Our Ref: WA/24/22/NMA

**Section 96A of the Town & Country Planning Act 1990 (as amended)
Town and Country Planning (Development Management Procedure) (England) Order 2015
(as amended) - Article 10**

Non-material amendment following grant of WA/39/18/PL for revision to front elevation.
48 The Meadows Walberton BN18 0PB

Drawing No Status Revision
181260/ 02 A

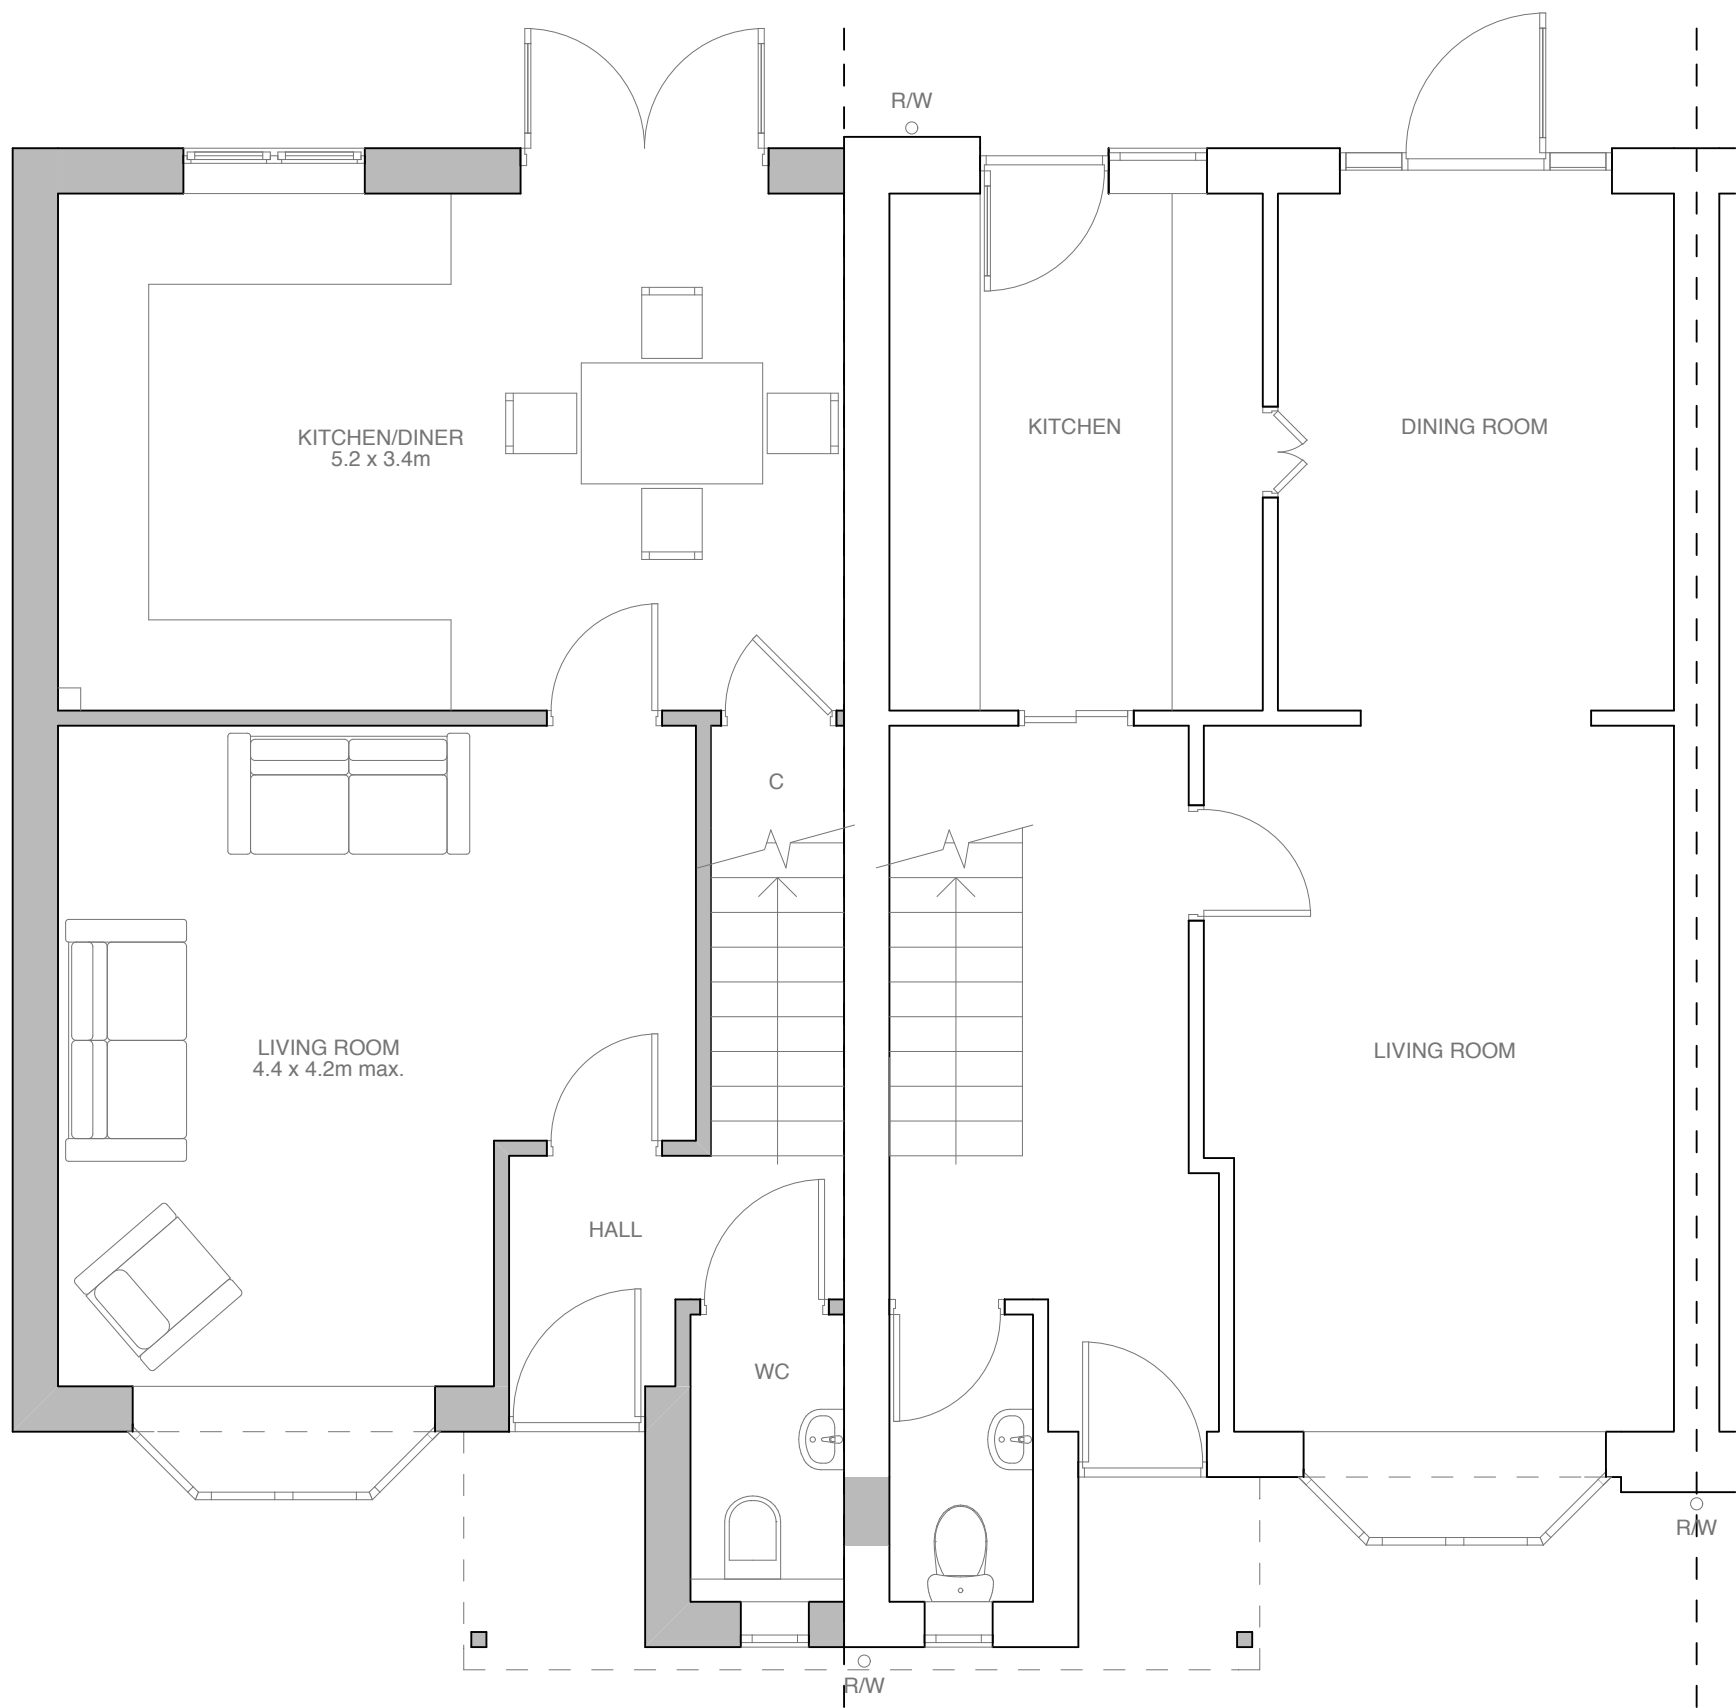
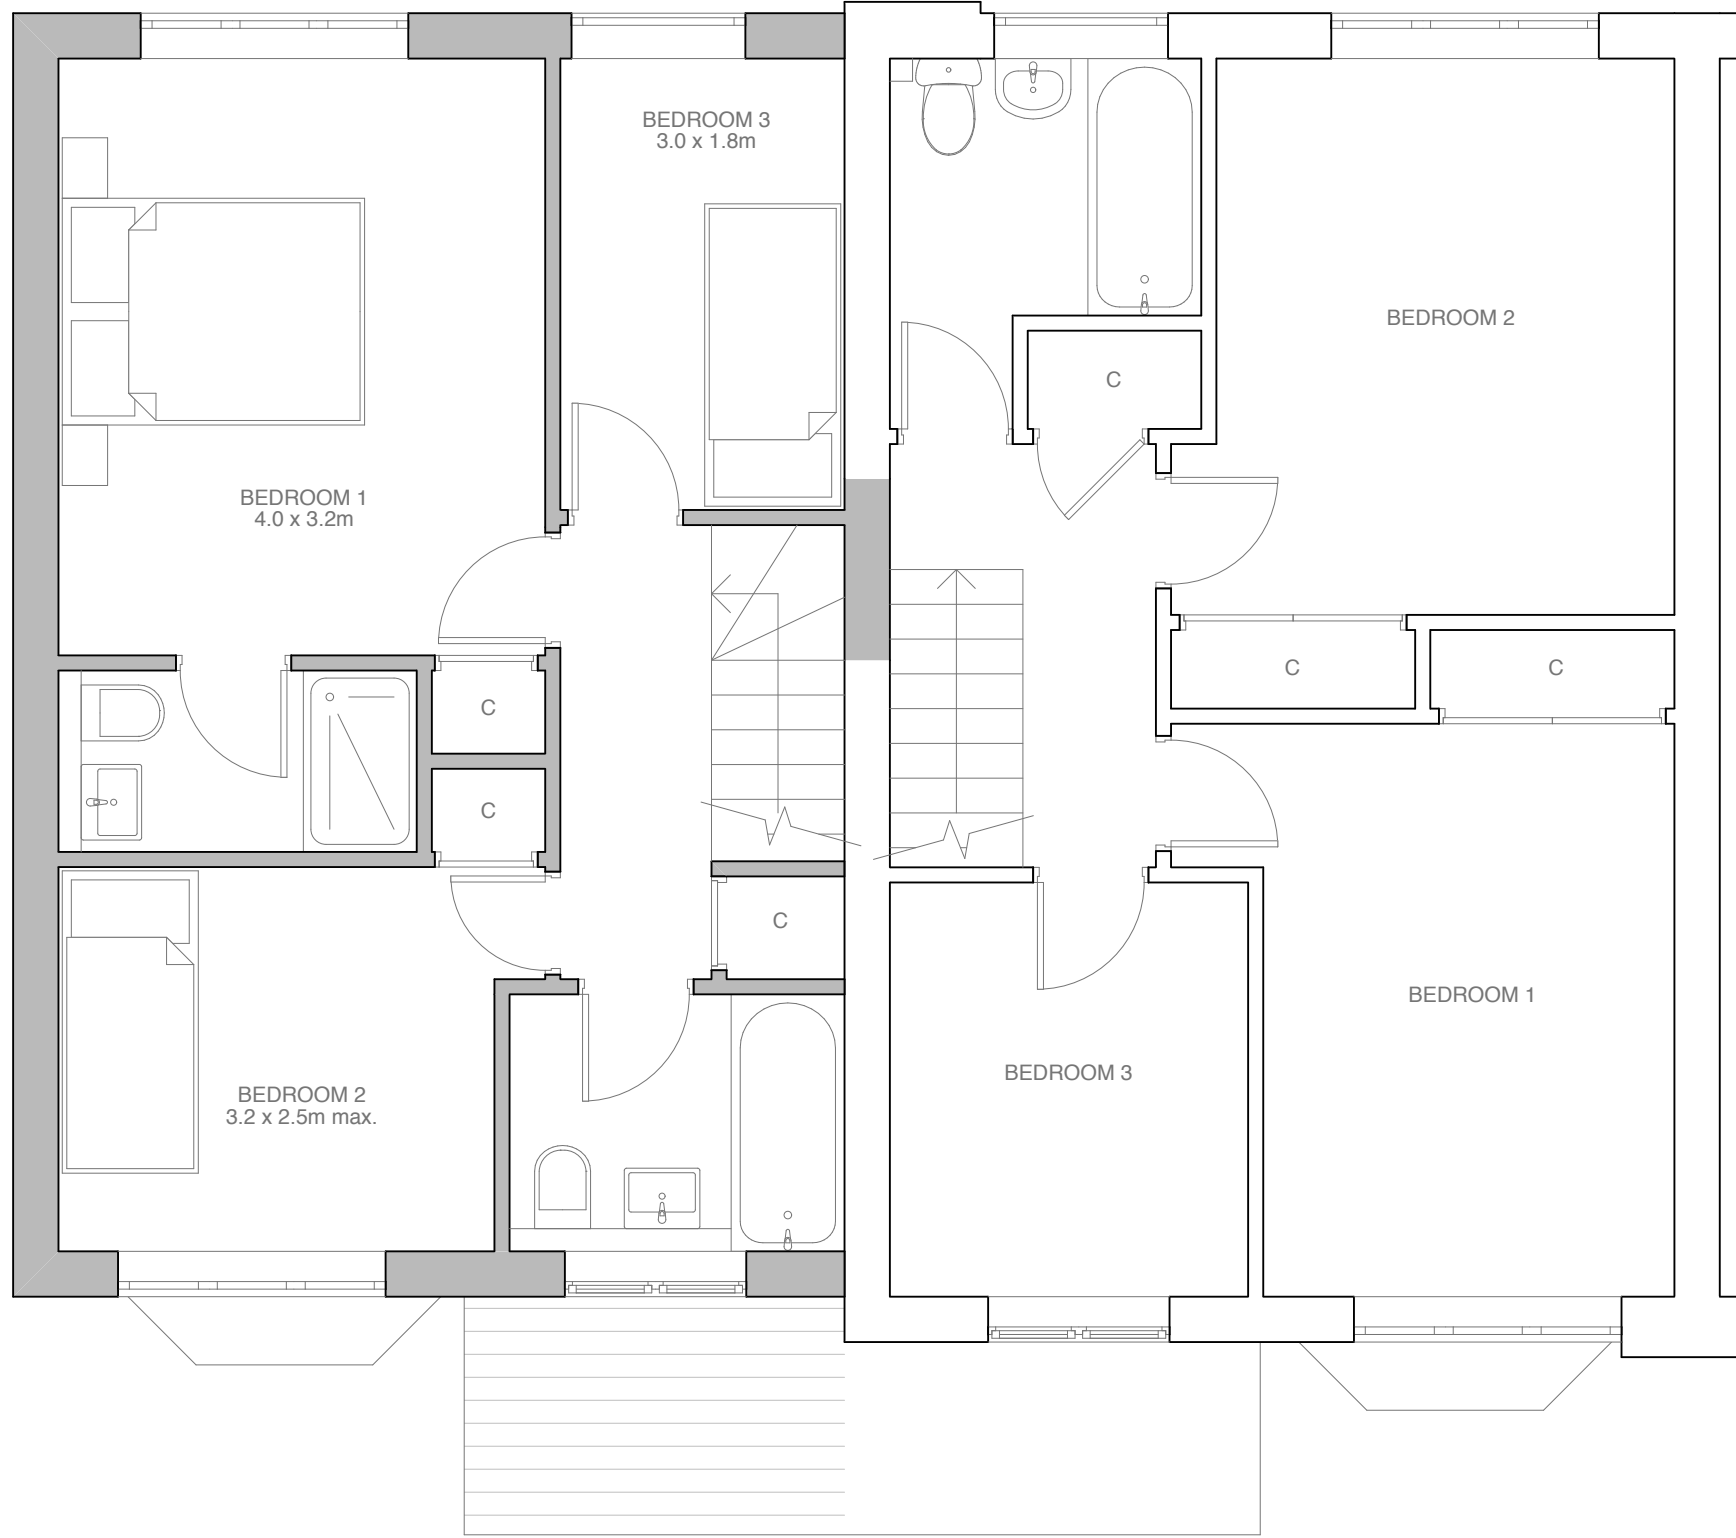
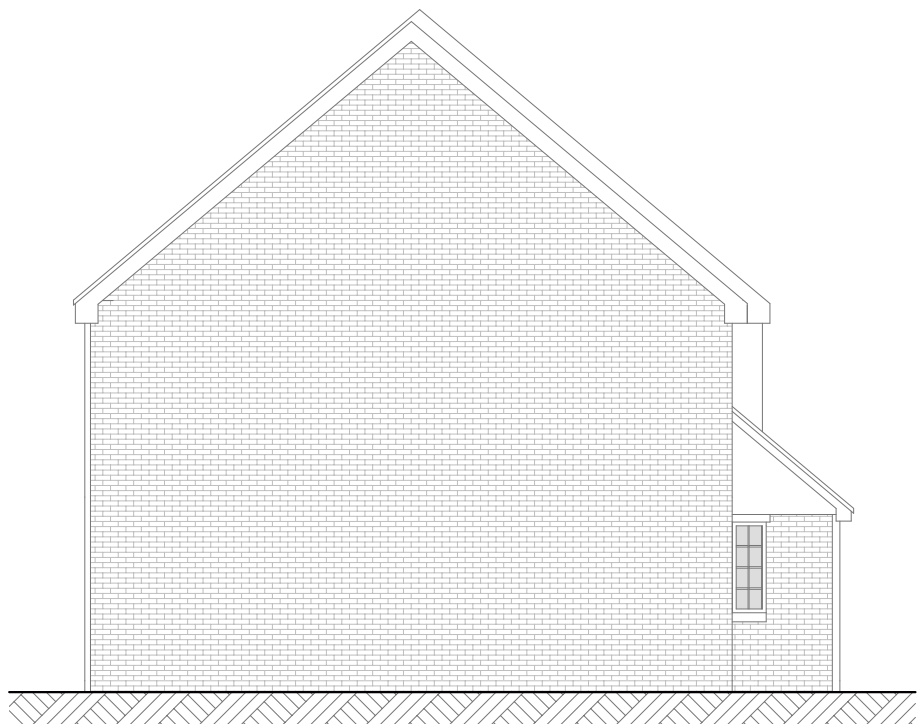
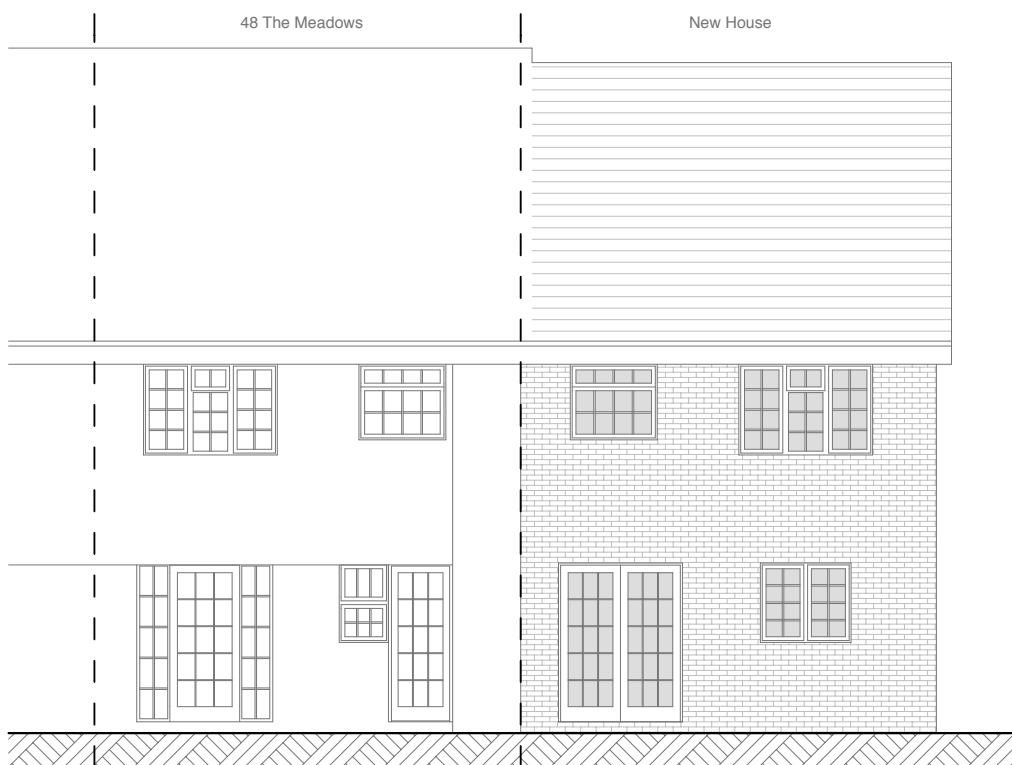
The reasons that these proposals have been accepted as Non-Material Amendments is because the proposed alterations namely the setting back of the front elevation of the new dwelling by 300mm, and the reduction in ridge line of the roof do not have a material impact upon the originally approved development and do not necessitate additional consultation and can therefore be considered under section 96A of the Town and Country Planning Act 1990.

From the information submitted I am able to take the alterations as a Minor Amendment to WA/39/18/PL. Accordingly the Proposed Plans and Elevations 181260/ 02 Revision A and Location & Block Plans 181260/03 Revision B are now the approved elevation, block and location plans.
